Your Ref: BE/113/17/RES

Our Ref: NW/ARU/16/10B

Re: Land West of New Barn Lane Bersted

Thank you for your correspondence of 13th September 2017, advising me of an application for Approval of reserved matters following outline consent BE/18/17/PL for appearance, landscaping, layout & scale for a mix of up to 90No residential units, associated open space, landscaping, access & car parking for which you seek advice from a crime prevention viewpoint.

Plots 29-33

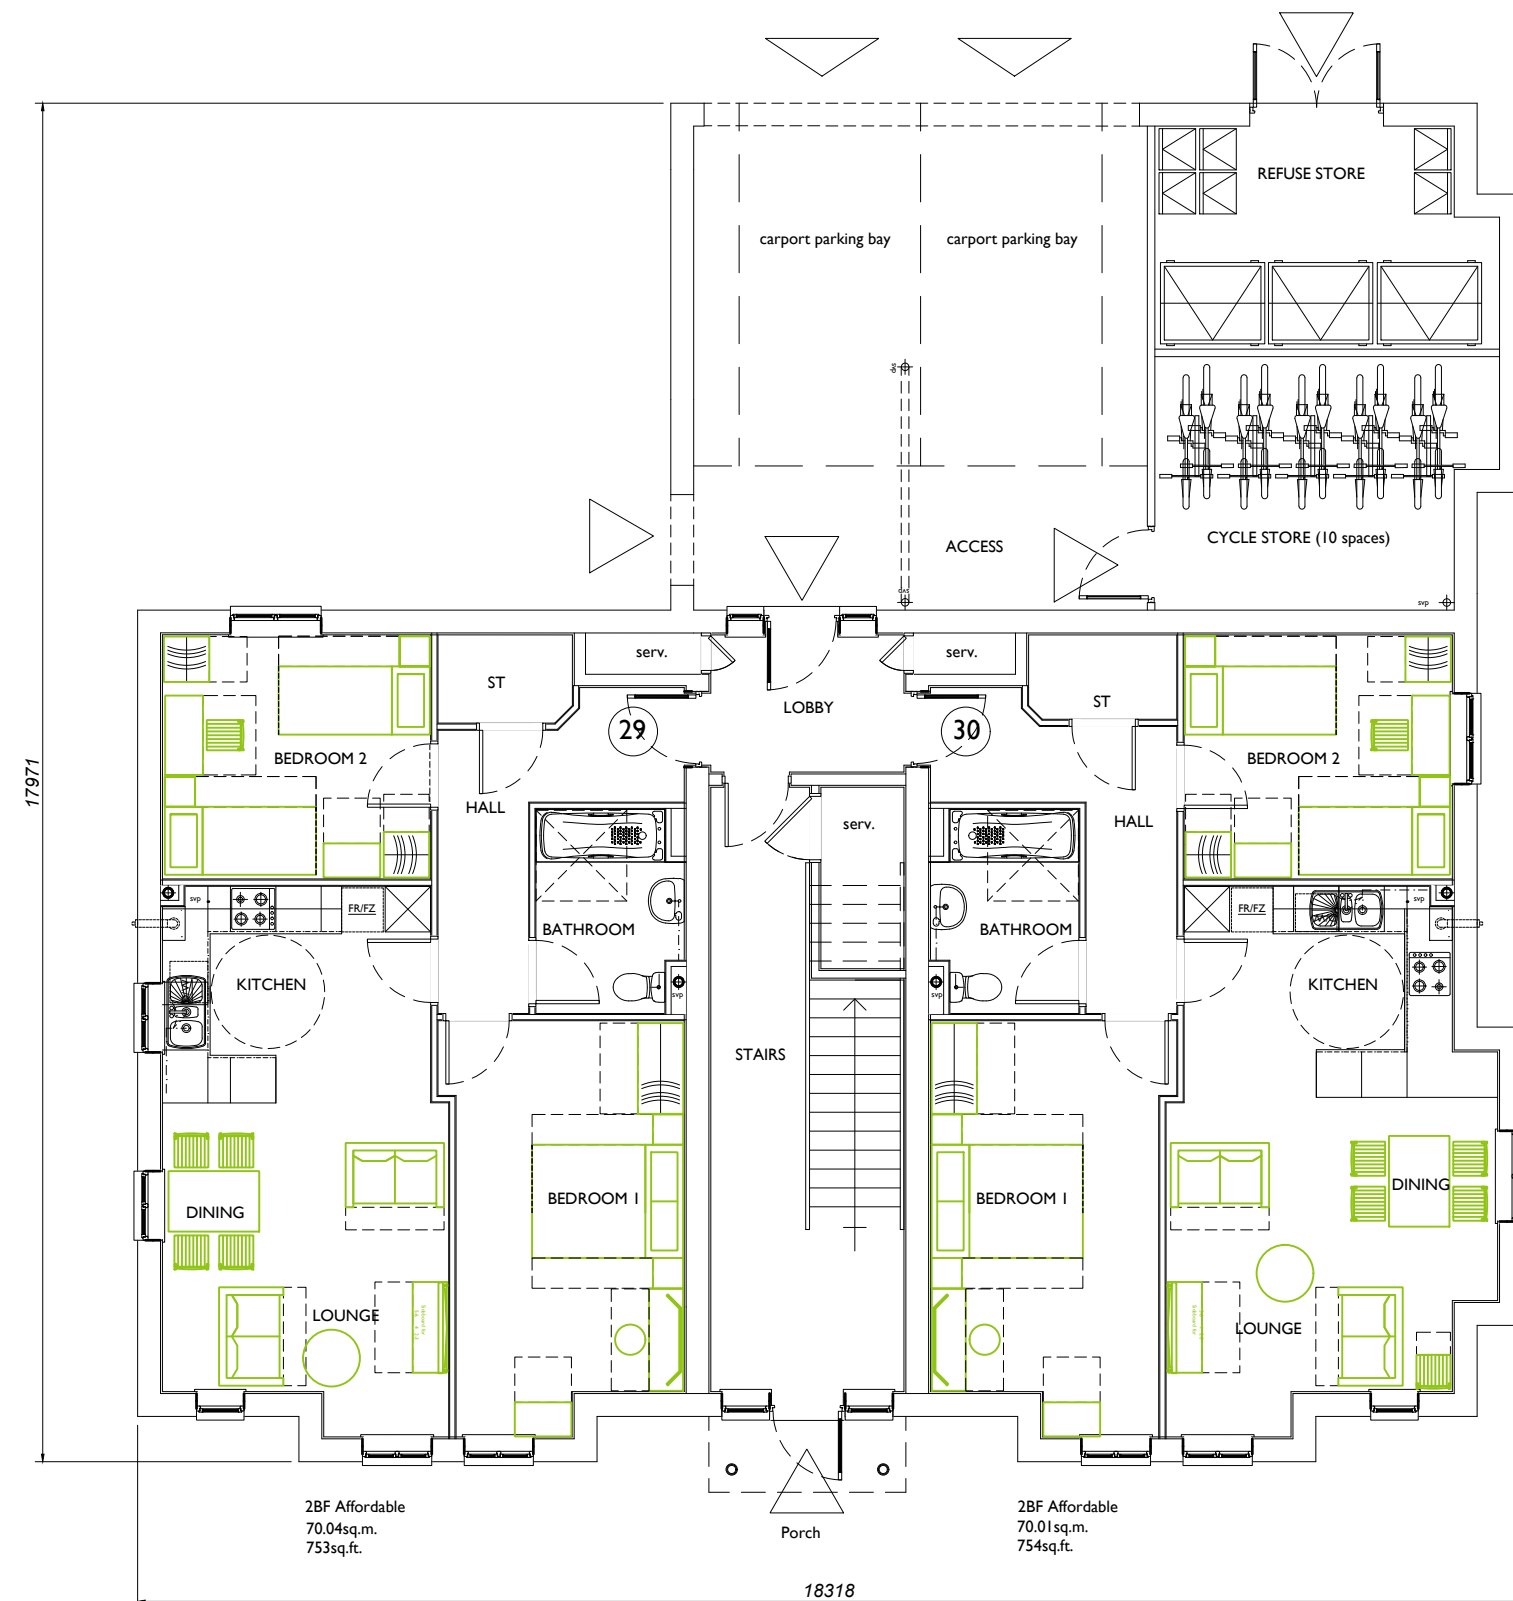
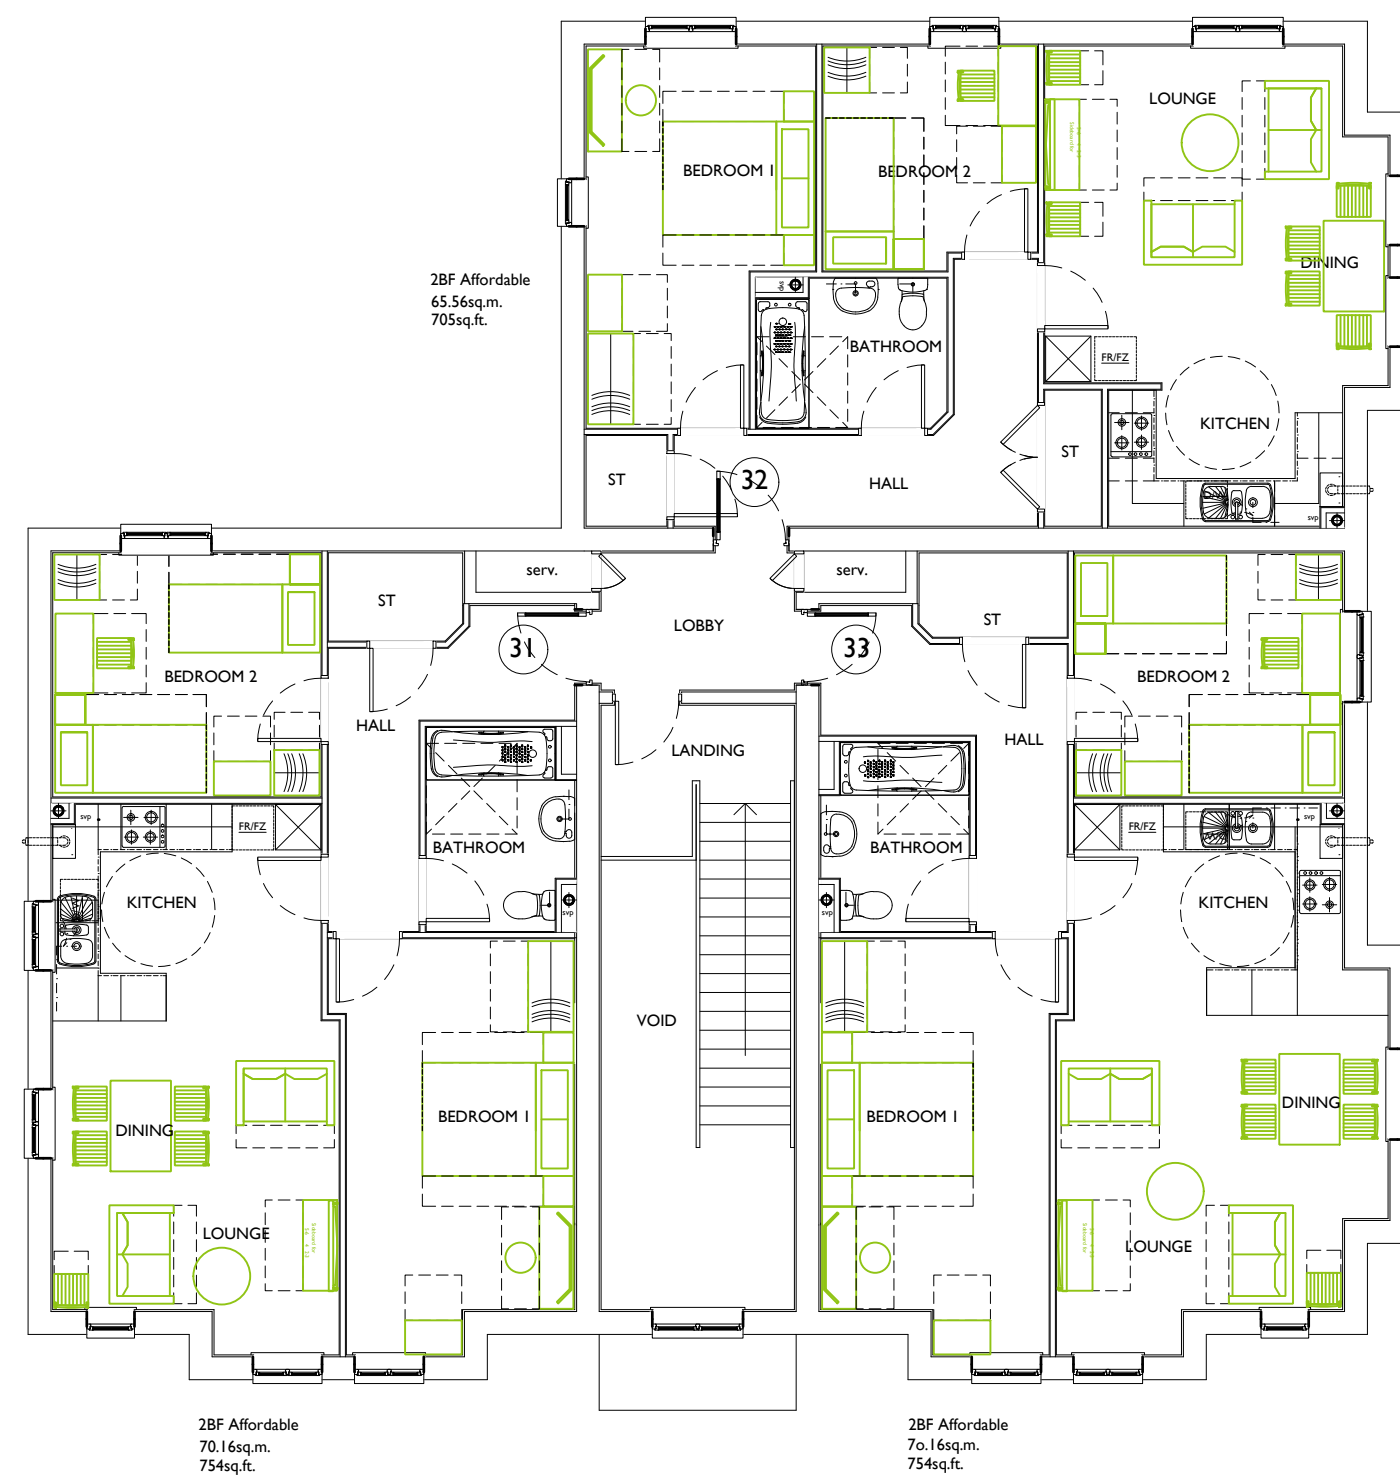
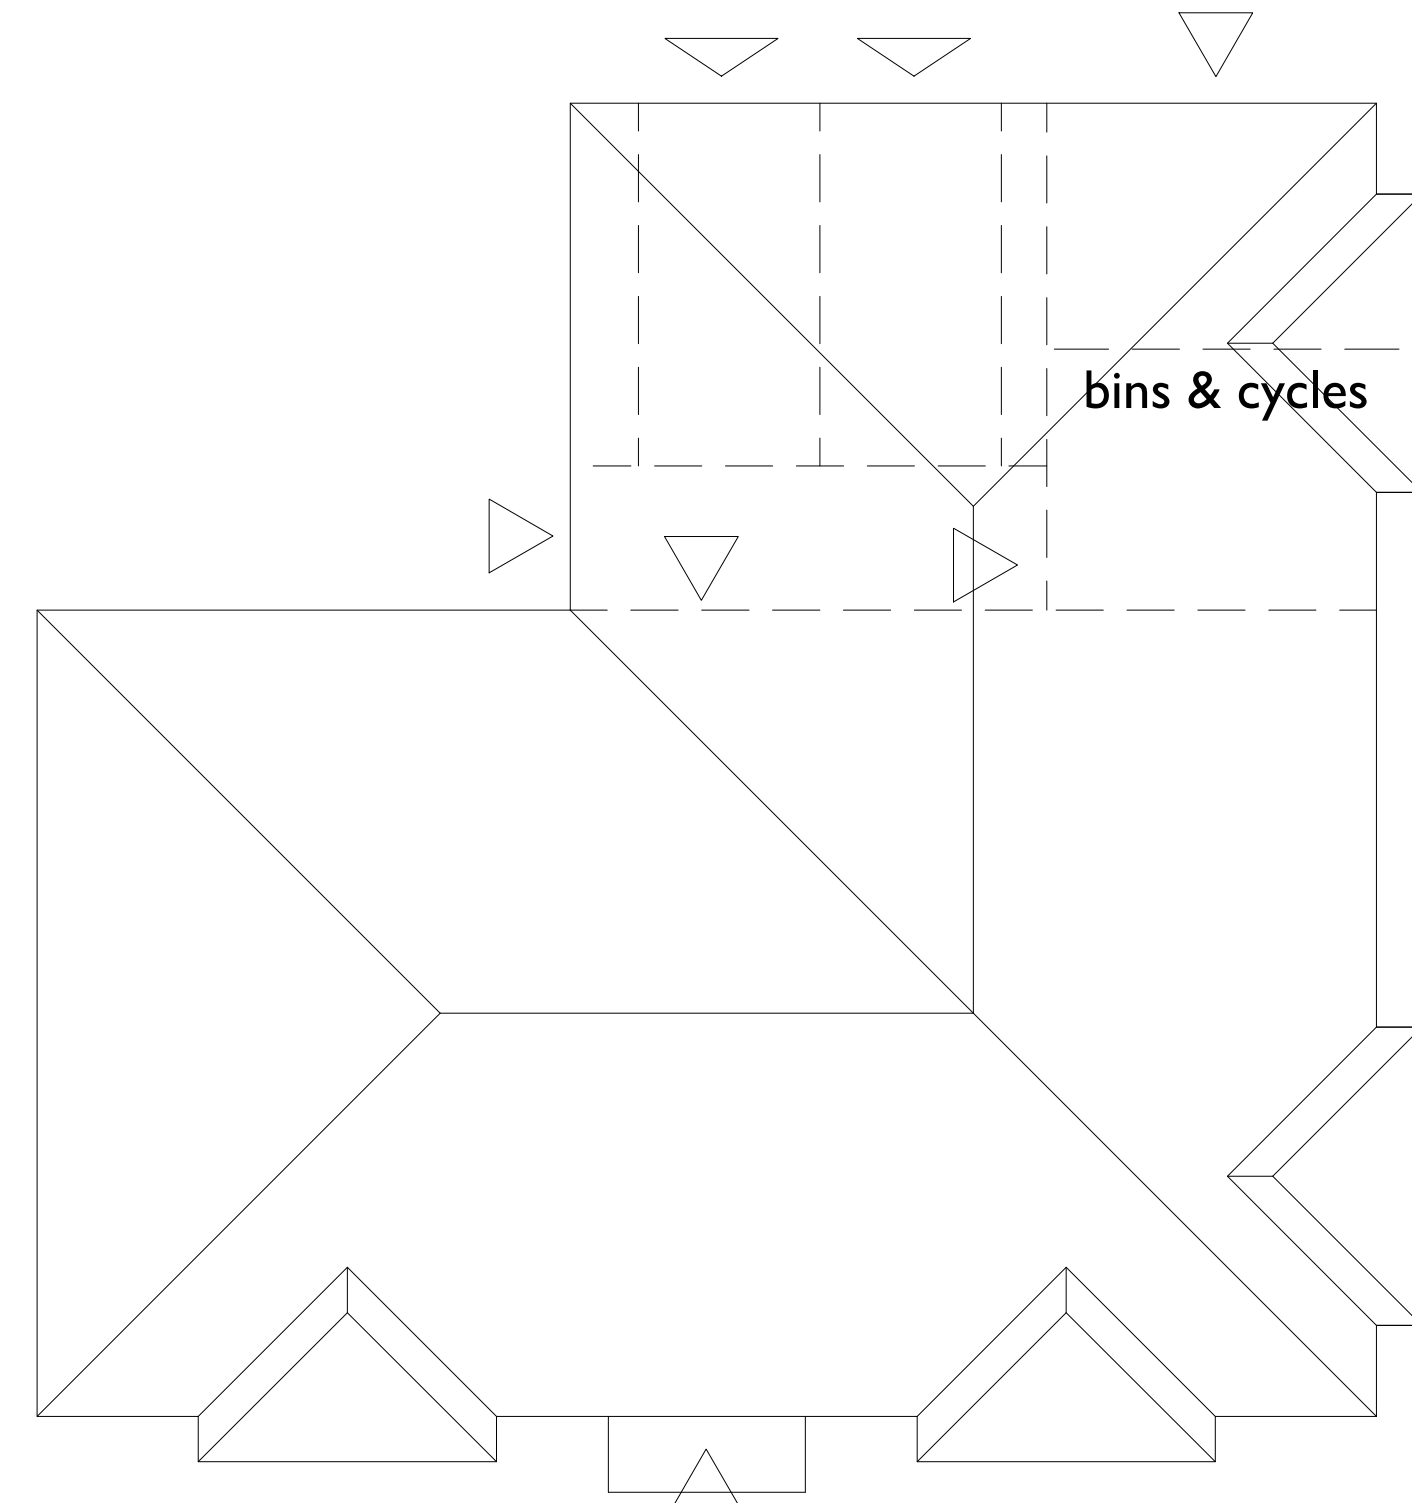
Following on from those comments I would also recommend there is lighting in the parking court containing parking bays 29-33 and parking court containing bays 43 -46 and 61-66.

I also recommend that the secure cycle stores have PIR lighting installed internally and that the front doors are lockable. A mechanical push button type of lock would be acceptable or a Sold Secure Silver hasp, staple & padlock.

Where there are proposed cycle stores with double doors, a door closer is to be fitted along with spring loaded automatic shoot bolts to the unlocked door to ensure it closes first. This arrangement would work very well for the refuse stores as well. Sheffield hoop style cycle stands are to be of galvanised steel bar construction of at least 3mm thickness.

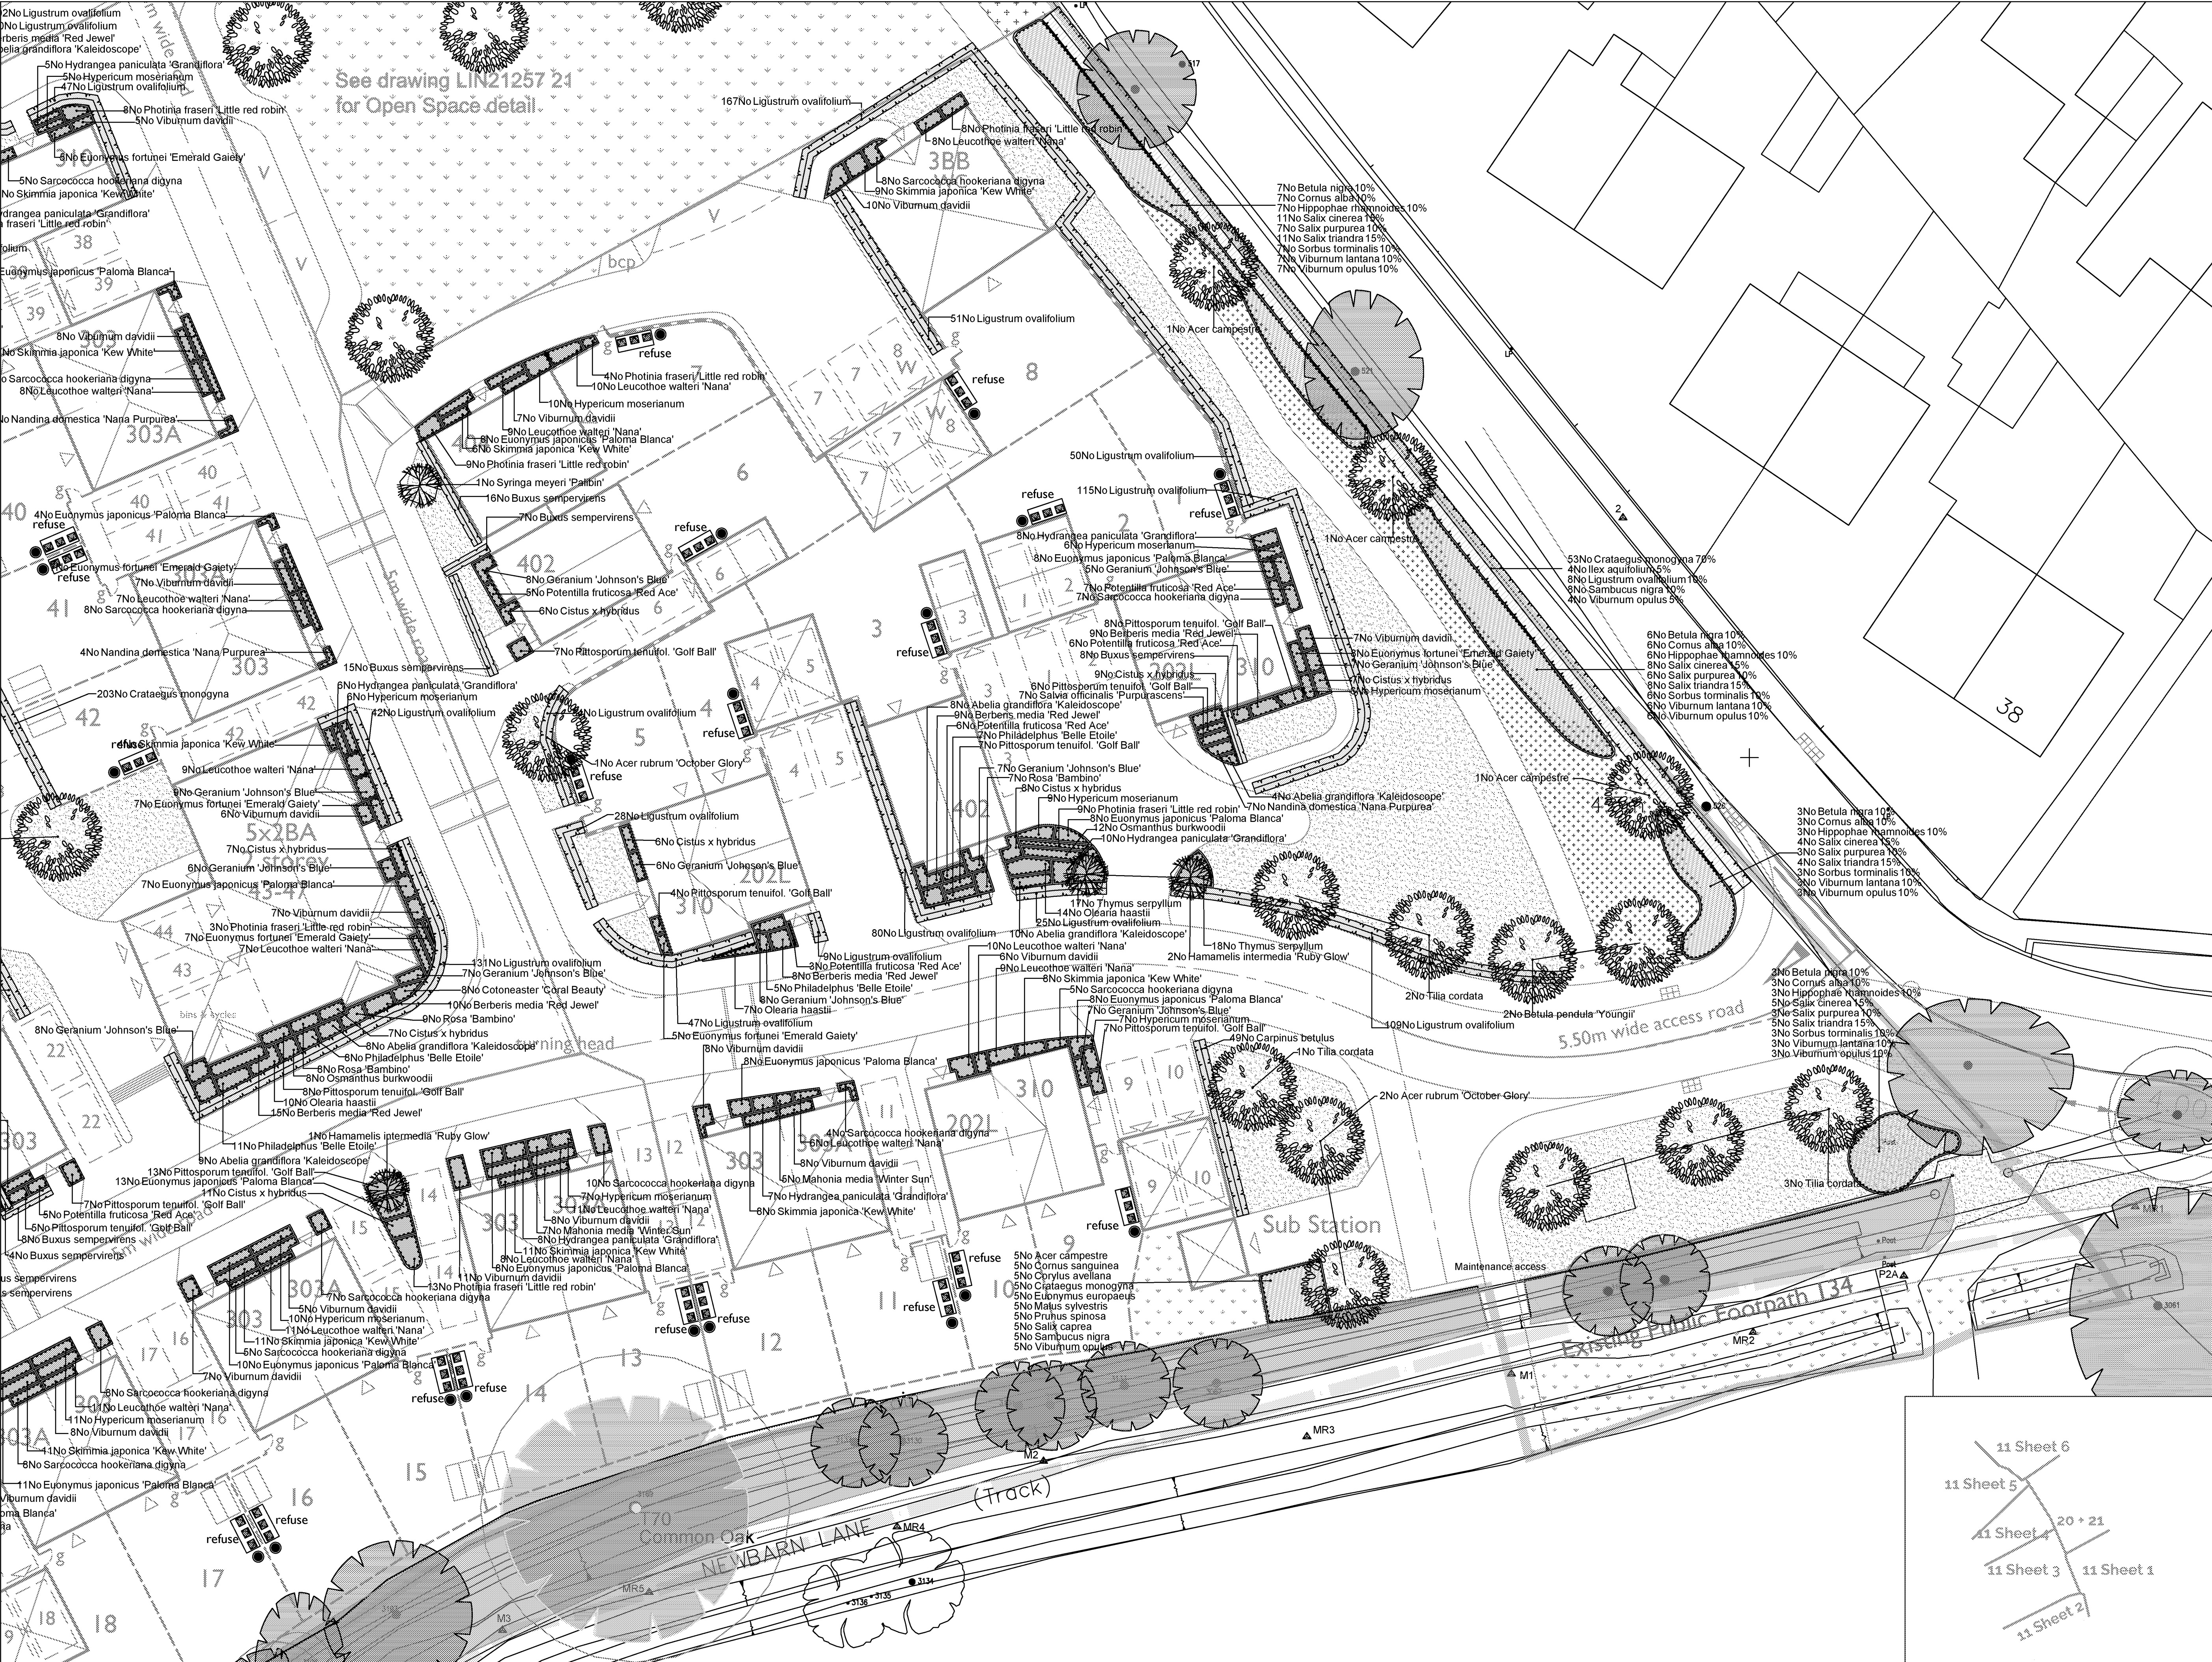
(There is good overlooking surveillance from the dwellings opposite the proposed area of play and public open space; however it will be necessary for these to be active rooms overlooking these public areas. Additionally it will be necessary to keep foliage low in order to maintain natural surveillance throughout; ground planting no higher than 1 metre with tree canopies no lower than 2 metres. Leisure areas including Local Areas of Play, Local Equipped Areas of Play and Neighbourhood Equipped Areas of Play require careful consideration when selecting their location. This must include inclusion of boundary fencing and landscaping of the area, but still provide natural surveillance and lighting as appropriate. The play areas should also reflect the differing age ranges; ensuring consideration has been given to all.)

I would recommend the hedging between the Locally Equipped Area of Play and the swale is increased in length to provide a dense barrier between them to prevent children running through or around either ends.
